Subject: **Request for Revision to Section 404 Nationwide Permit, Section 401 Water Quality Certification** for the Proposed Replacement of Bridge No. 8 on NC 194 over the North Fork New River in Ashe County; TIP BR-0002, Division 11, Debit \$240 from WBS Element 67002.1.1

Reference: Section 404 Permit, (Action ID SAW-2019-02373), issued February 11, 2020
Section 401 Water Quality Certification (NCDWR Project No. 20191658), issued December 19, 2019

Please see enclosed copies of the Revised Stormwater Management Plan and Revised Permit Drawings (Sheet 2 of 7, Sheet 3 of 7 and Sheet 7 of 7).

SITE 2
3X

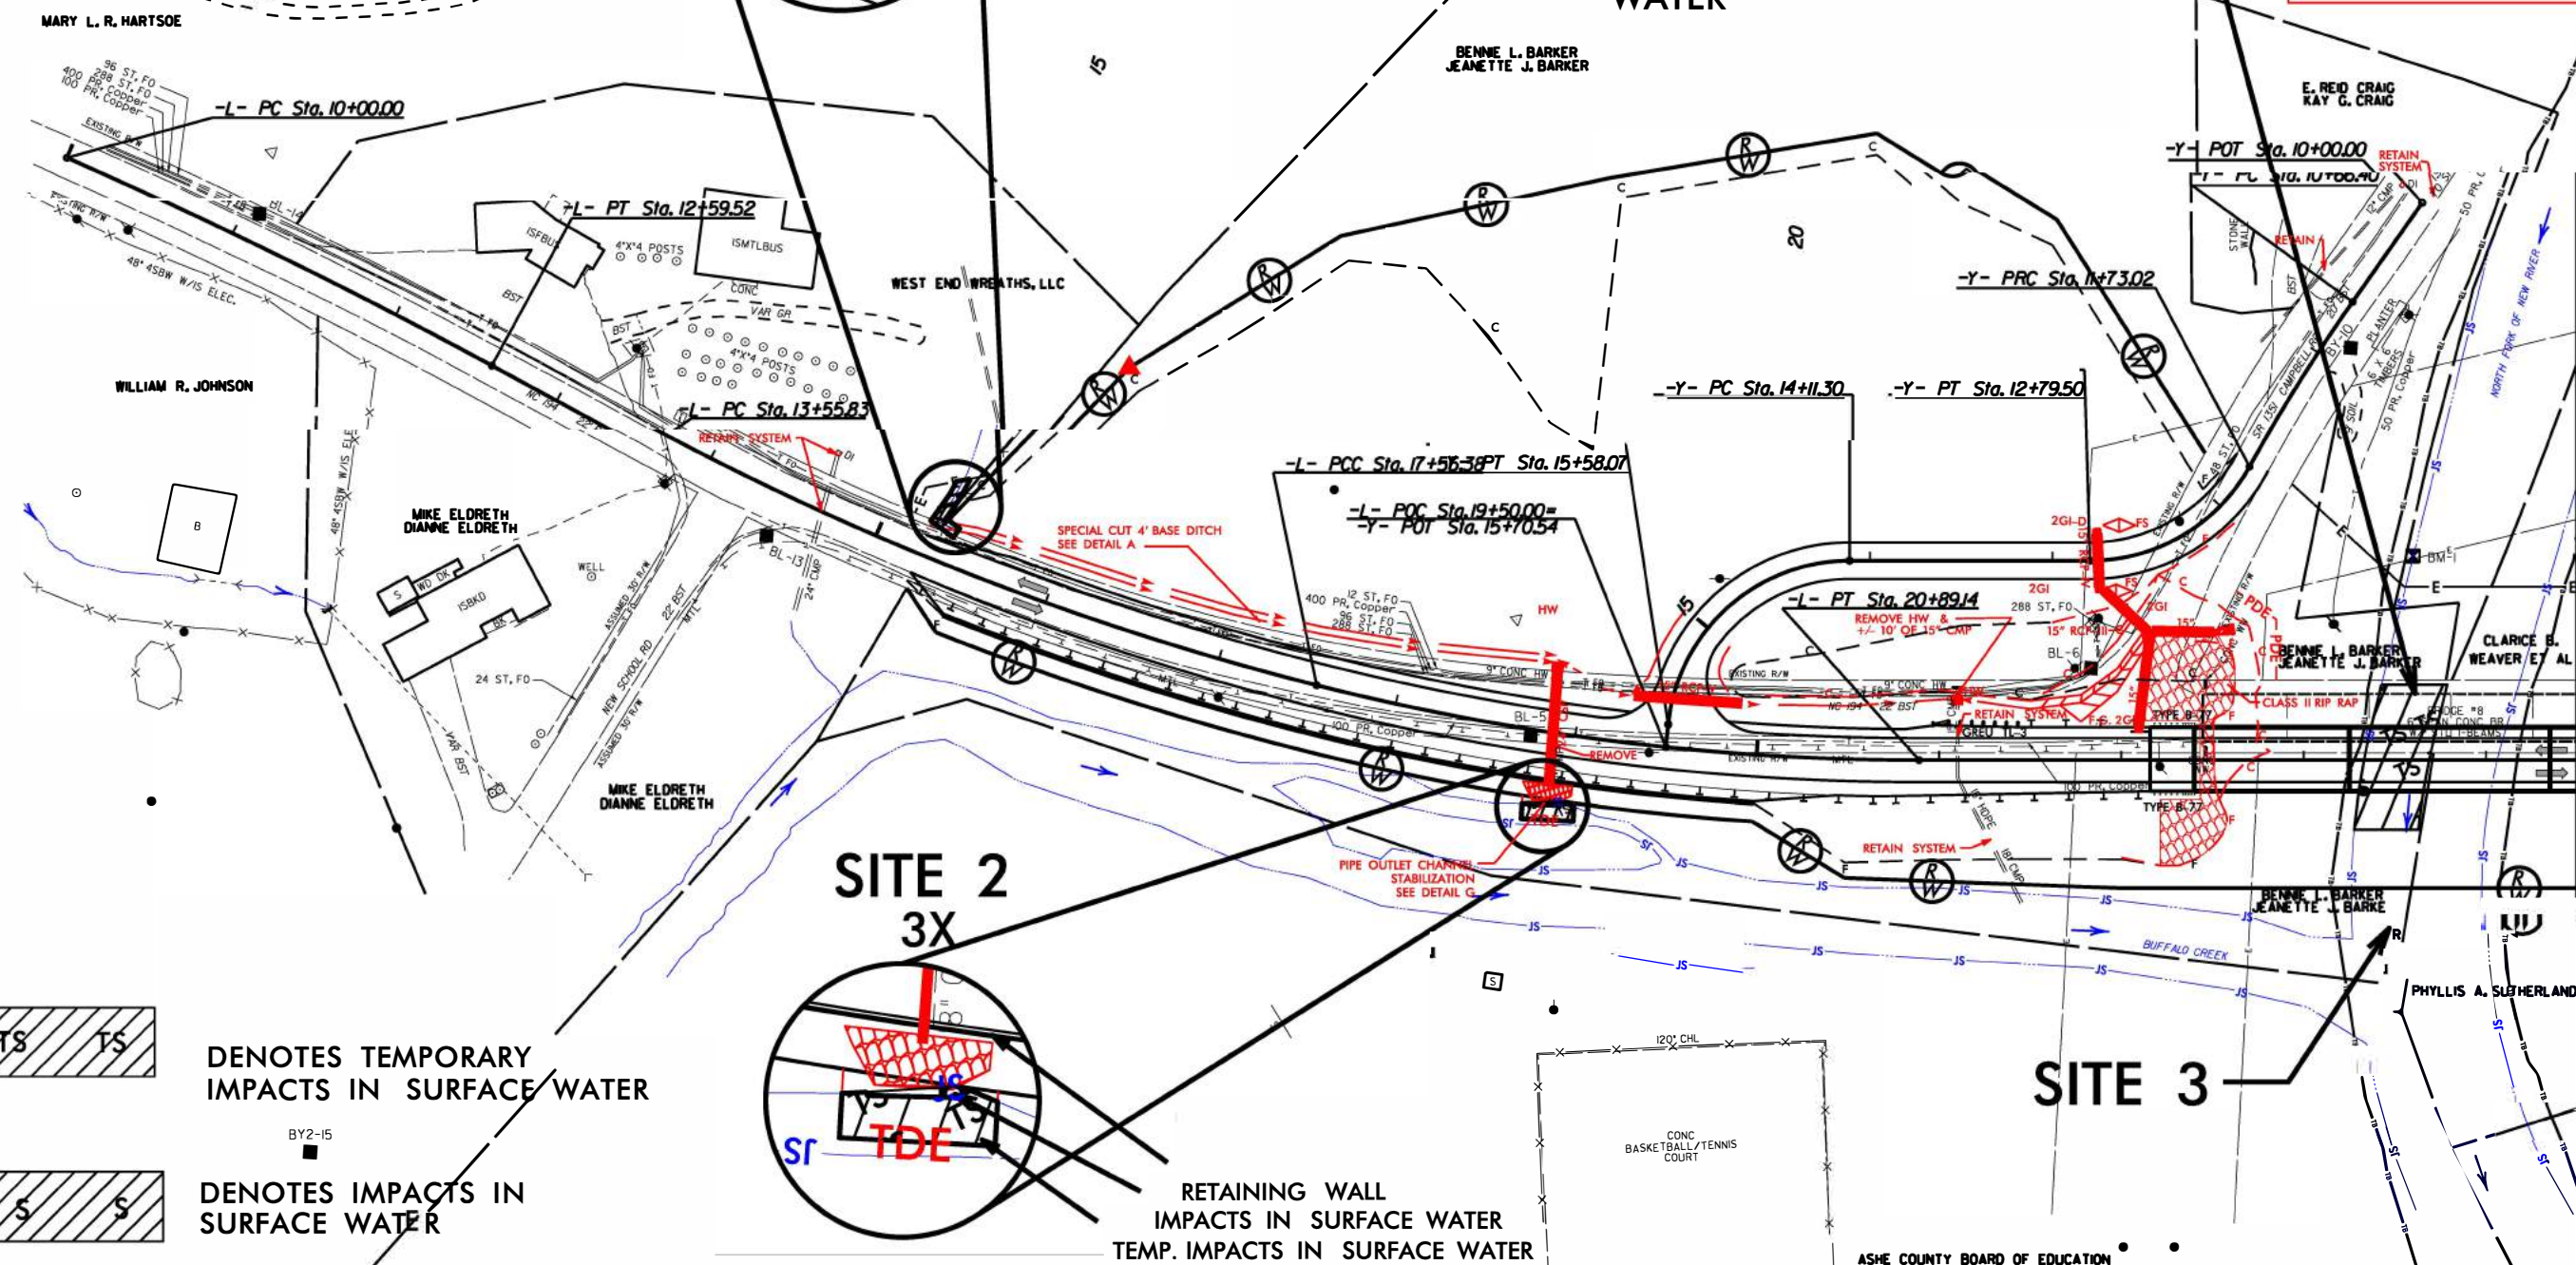
The NCDOT Geotechnical Unit has performed additional scour calculations that prompted changes to the retaining wall located parallel to Buffalo Creek. This resulted in to changes to the pervious permitted design.

The retaining wall, established to avoid impacts to Buffalo Creek, will shift five additional feet away from the stream.

A new corrugated steel pipe (CSP) that was previously proposed to exit through the wall and discharge into Buffalo Creek, will now be shifted eastward, outside of the wall area. This will allow the pipe to outlet approximately 9 feet further away from Buffalo Creek than the original design.

Permanent impacts to Buffalo Creek reduced by 3 lf (from 18 lf to 15 lf) required for the keyed-in bank stabilization in Buffalo Creek.

Temporary impacts have increased 31 lf (from 11 lf to 42 lf). This is the result of the need to remove the 18" CMP that was going to be replaced and discharged through the wall.
